Rezoning Transportation Analysis
Petition Number: Insert Zoning Petition #2021-270
General Location Identifier: 10502126, 10502127

Date	Description
04-12-2022	First Review (AO)
05-25-2022	Second Review (AO)

The site is located on Rocky River Road, a State-maintained minor thoroughfare, South Devon Street, a City-maintained local street, and Harris Station Boulevard, a private local street. A Traffic Impact Study (TIS) is not needed for this site. The petitioner has committed to right-of-way dedication along Rocky River Road, constructing an 8-foot planting strip and 12-foot multi-use path along the site's frontage on Rocky River Road to meet the City's Charlotte BIKES policy and constructing a left-turn lane into the site off of Rocky River Road. Site plan revisions are needed to meet ordinance requirements and/or the outstanding items including, but not limited to committing to construct ADA curb ramps at proposed street intersections, and utility relocations to be determined and coordinated during permitting. Further details are listed below:

RZ-2

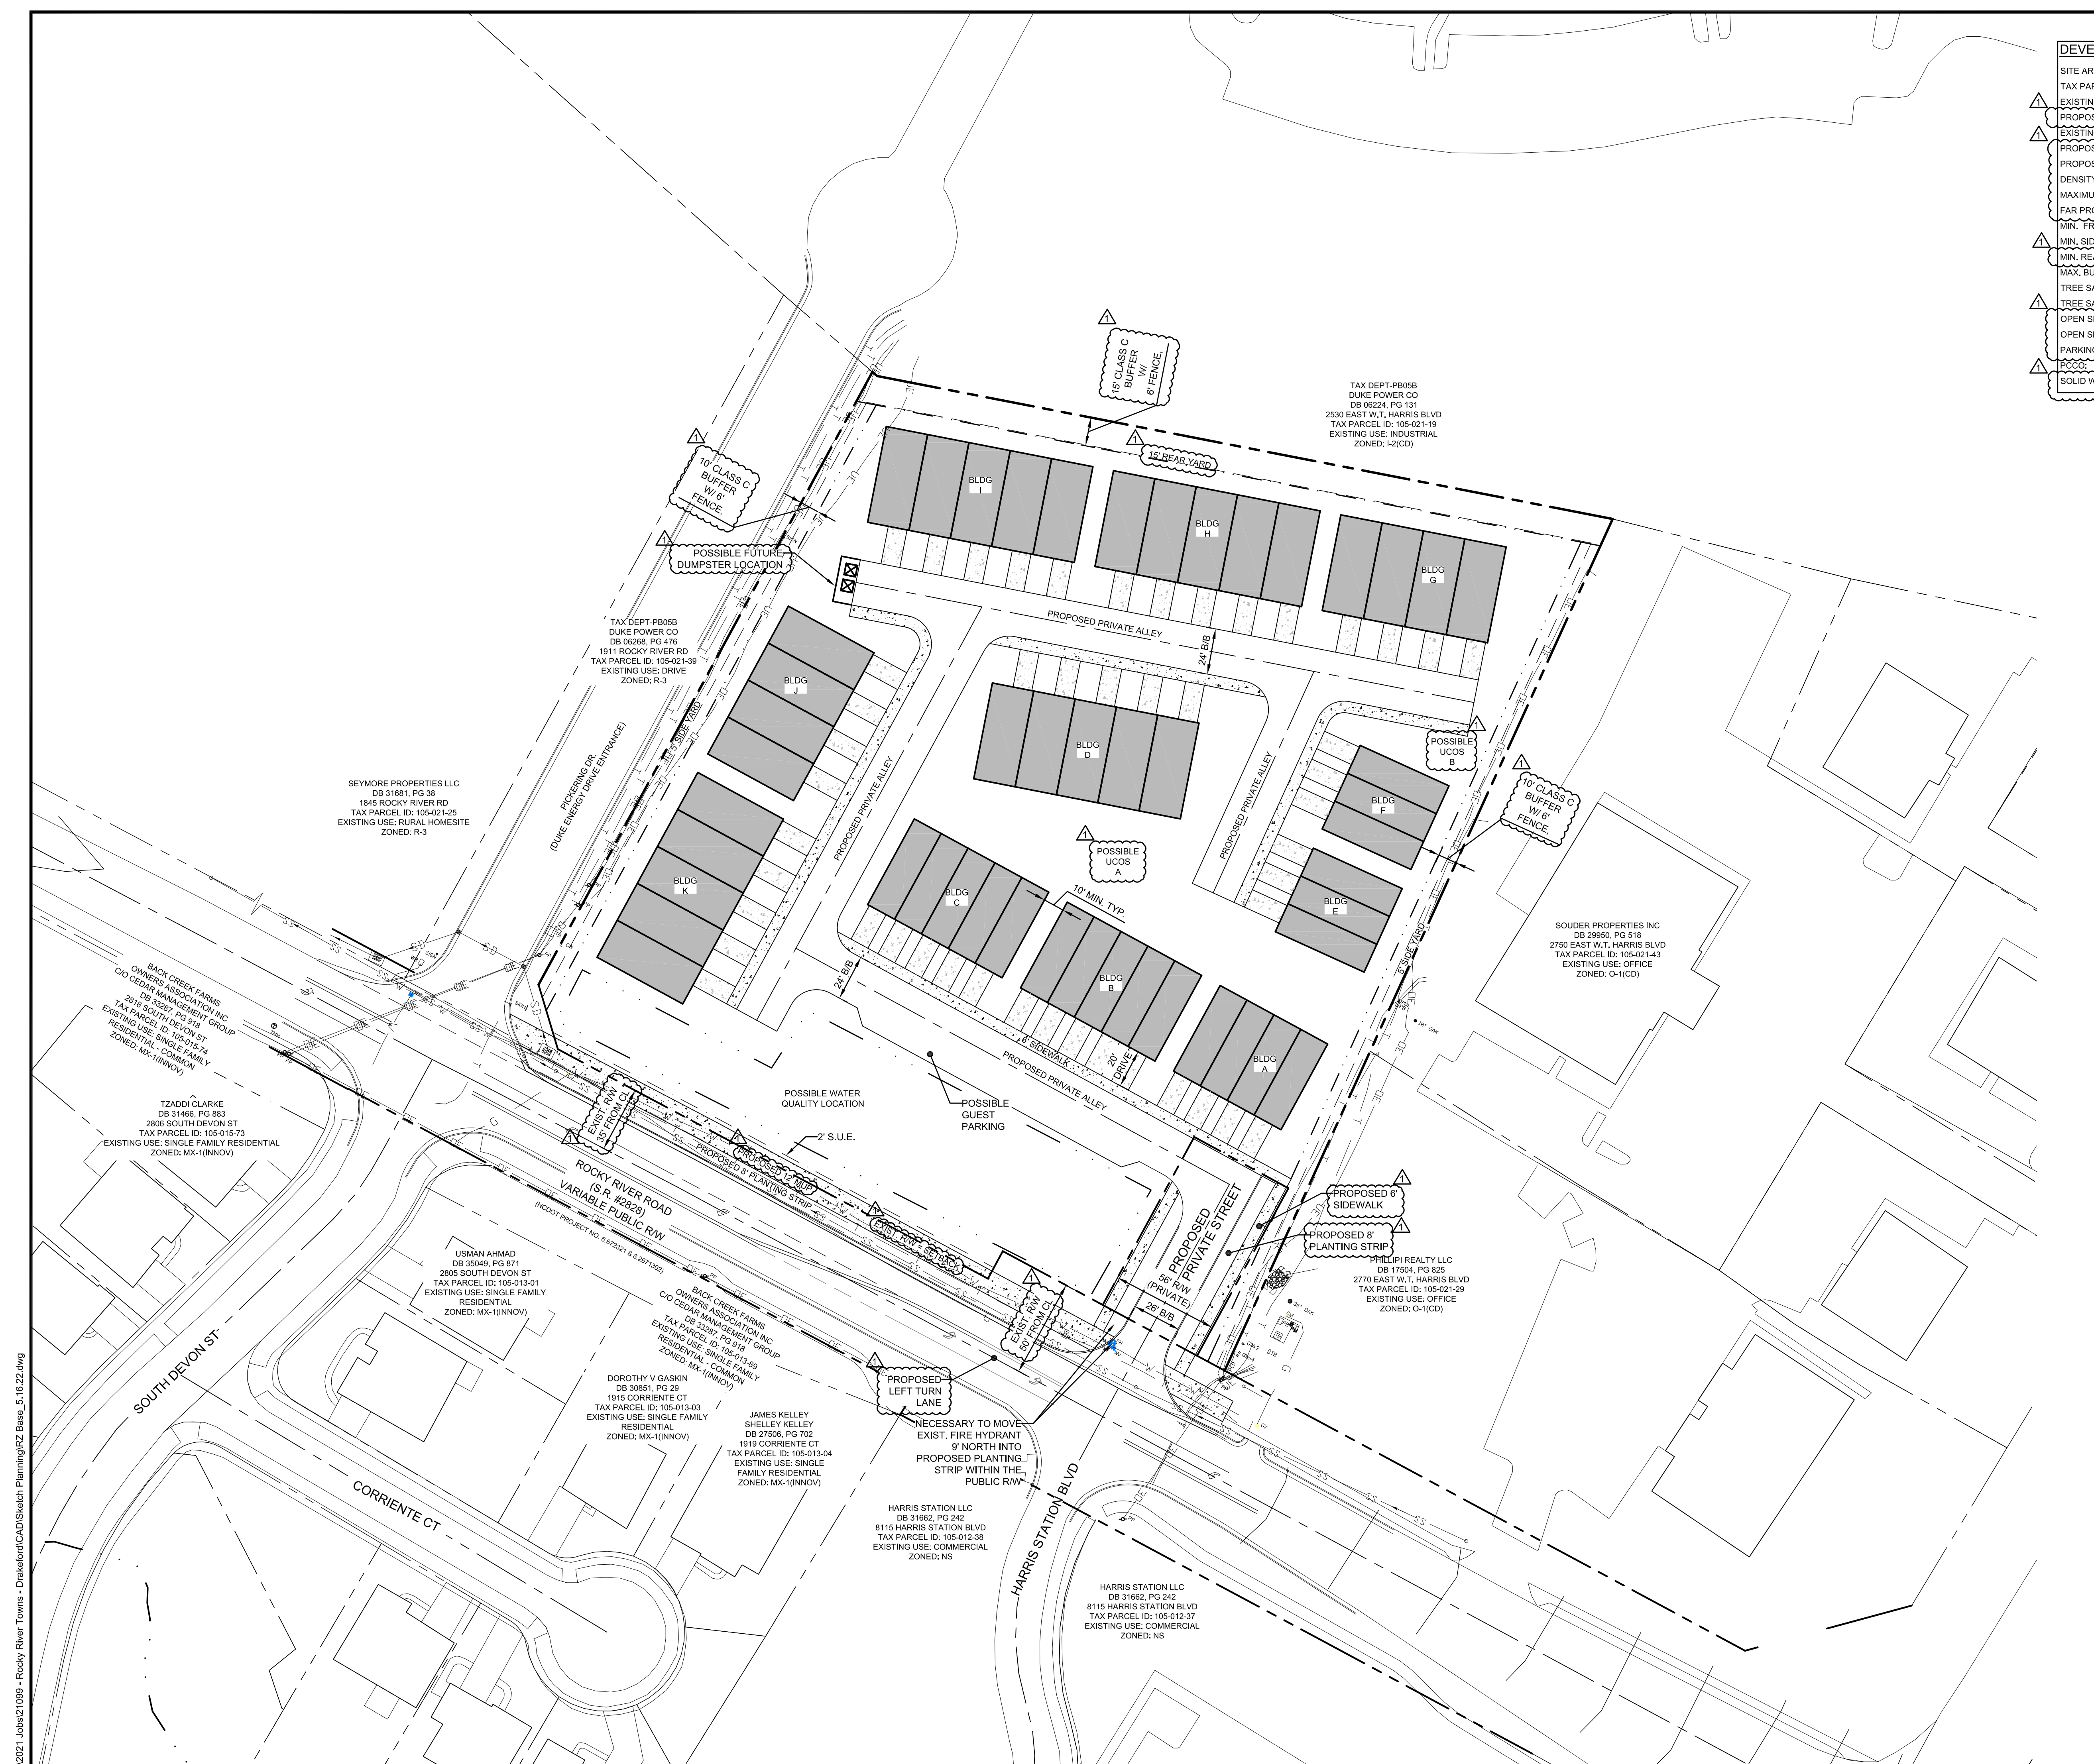
1. **Outstanding Comment from 04-12-2022:**

Curblin:

- a. **Rocky River Road:** Distance from centerline to back of curb: 19 feet

Label and dimension the curb and gutter from the centerline for each road on the site plan.

- 11. **New Comment (New Site Plan, 5-16-22):** Revise site plan and conditional note(s) to commit to relocating existing storm drainage infrastructure to location to be determined during permitting.

- 12. **New Comment (New Site Plan, 5-16-22):** Revise site plan and conditional note(s) to commit to constructing ADA curb ramps at proposed street intersections.
